From: Thomas Callaway
Sent: 13 June 2014 11:19
To: Planning.Responses
Subject: RE: Planning Consultation on: BE/63/14/PL

To: **Engineers (Fluvial Flooding)**

NOTIFICATION FROM ARUN DISTRICT COUNCIL
Town & Country Planning Act 1990 (as amended)
Town and Country Planning (Development Management Procedure) (England) Order
2010 (as amended)
Planning Permission
APPLICATION **BE/63/14/PL**
NO:

Description of Works: Installation of Solar Farm comprising erection of solar arrays, inverters, transformers, equipment housing, security fencing, internal tracks & ancillary equipment. Departure from the Development Plan.

Landscape Masterplan

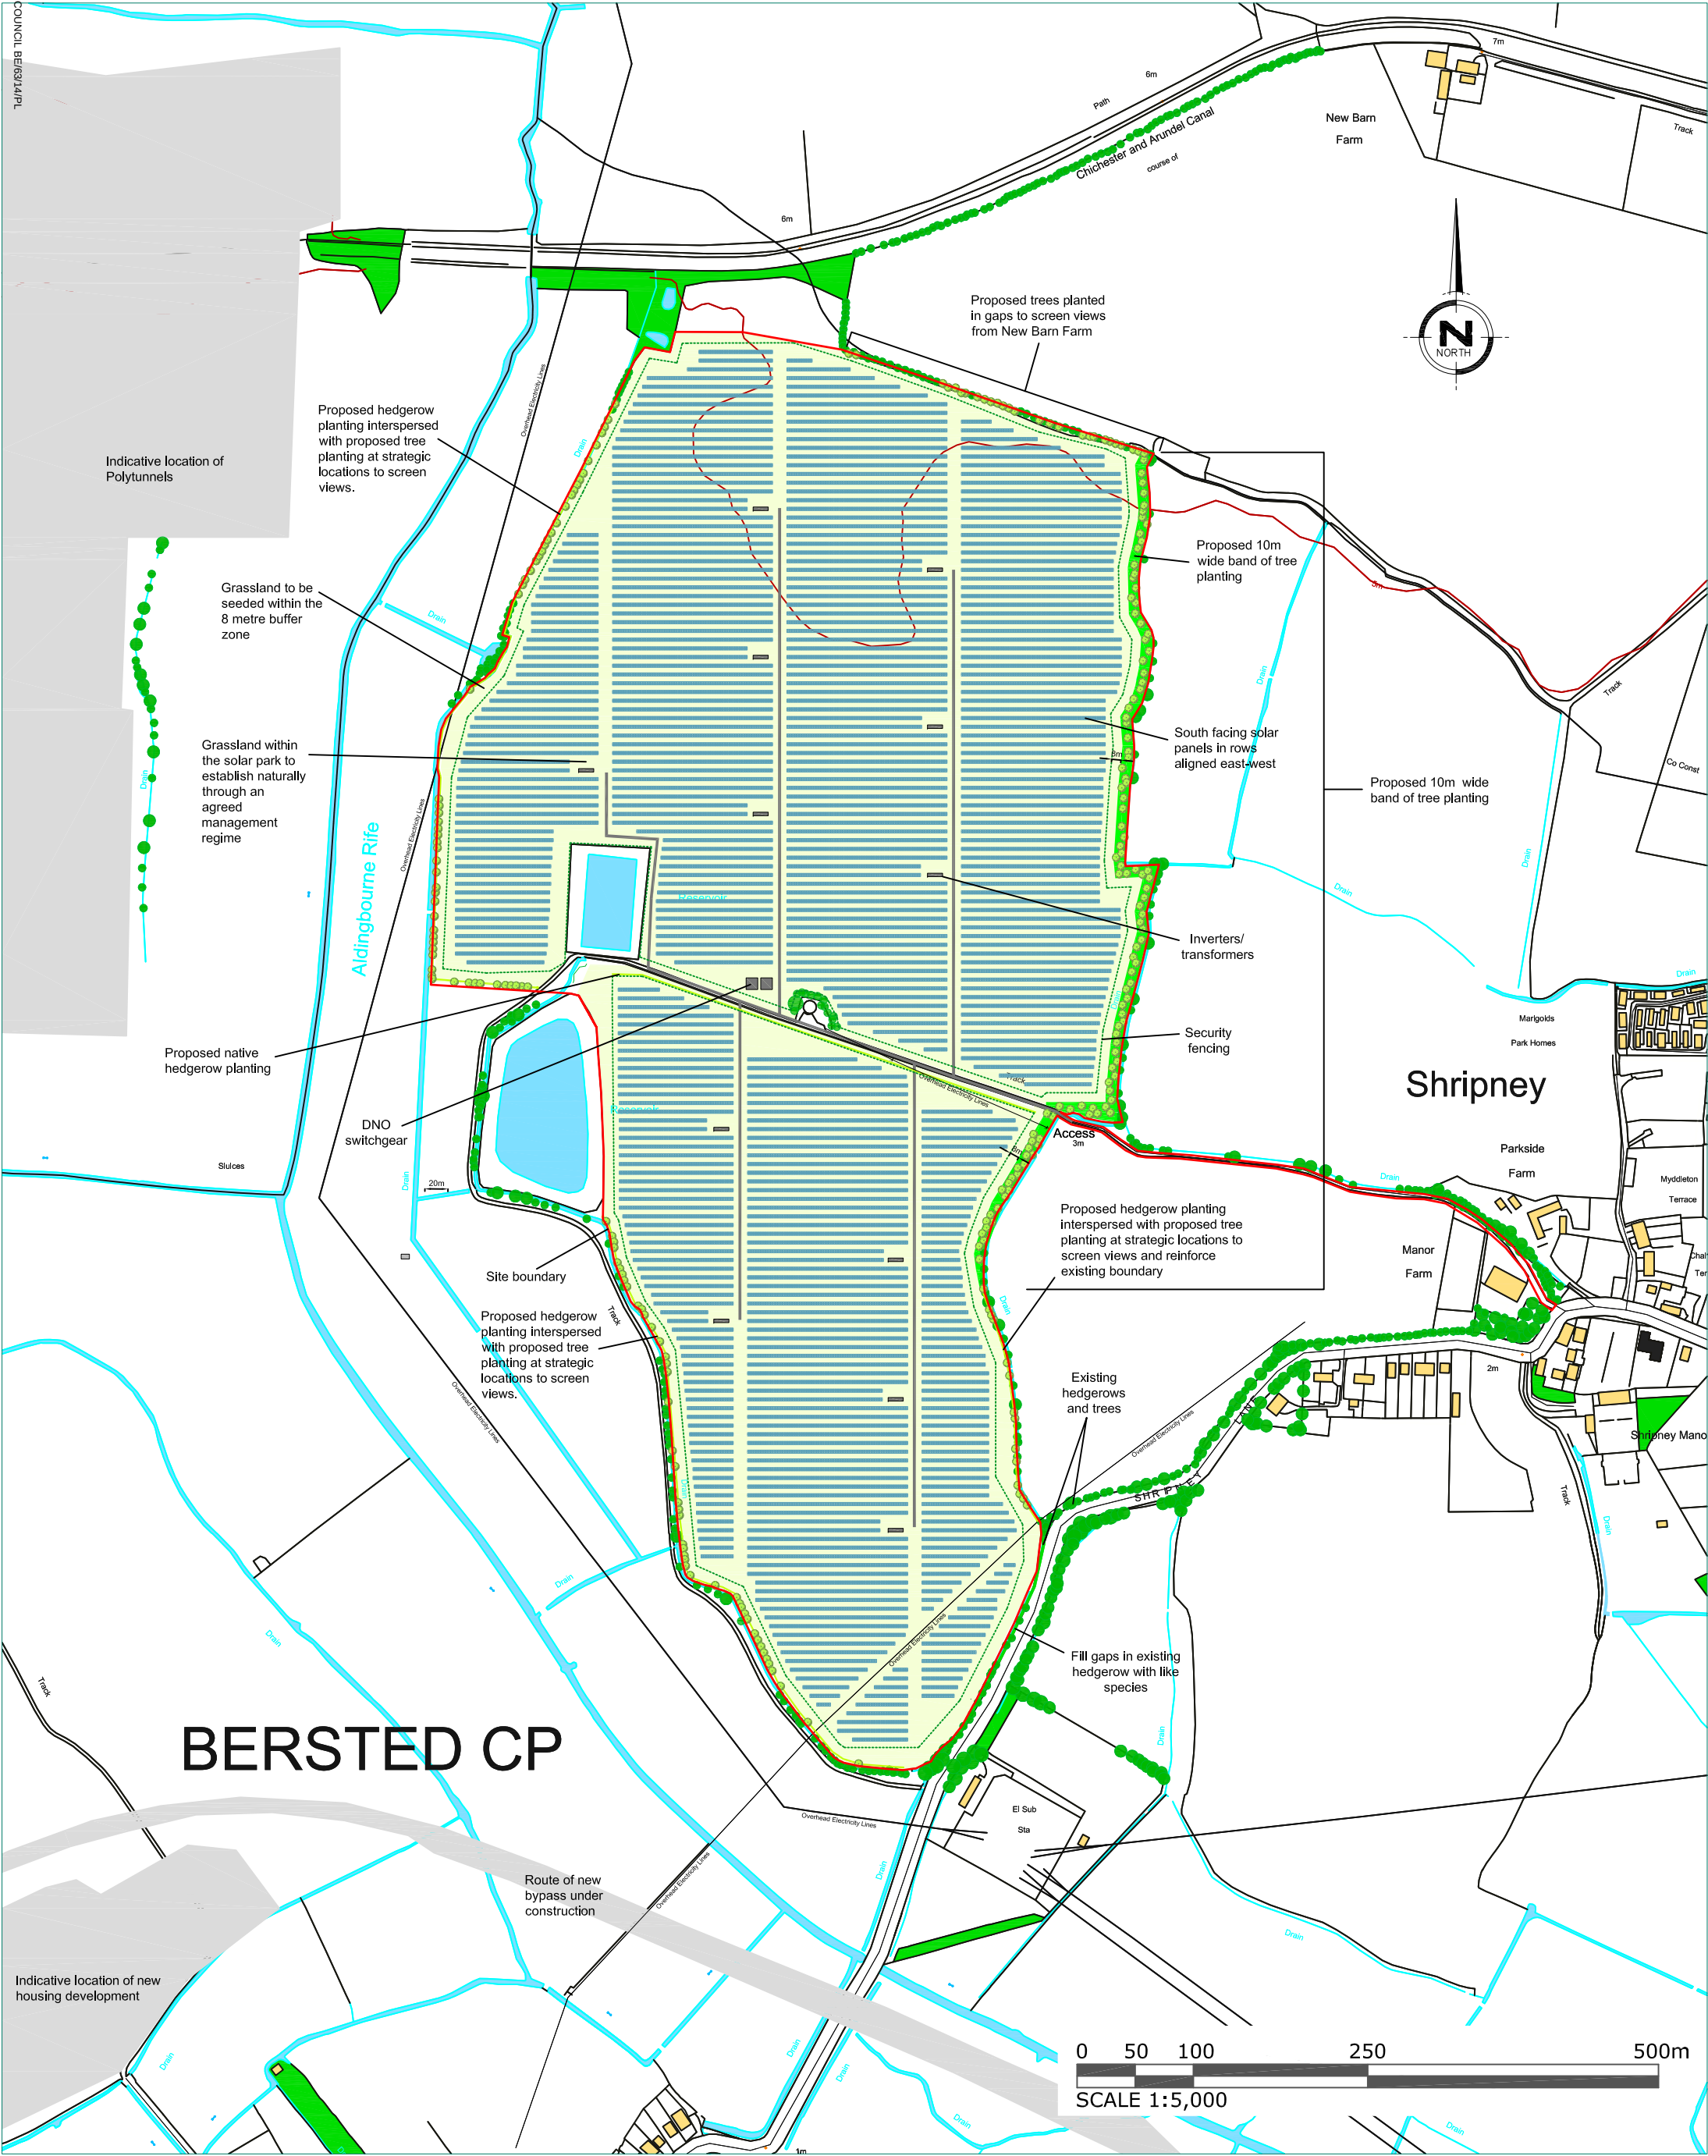
It appears that sufficient easement has been retained between the fence and any watercourse for maintenance.
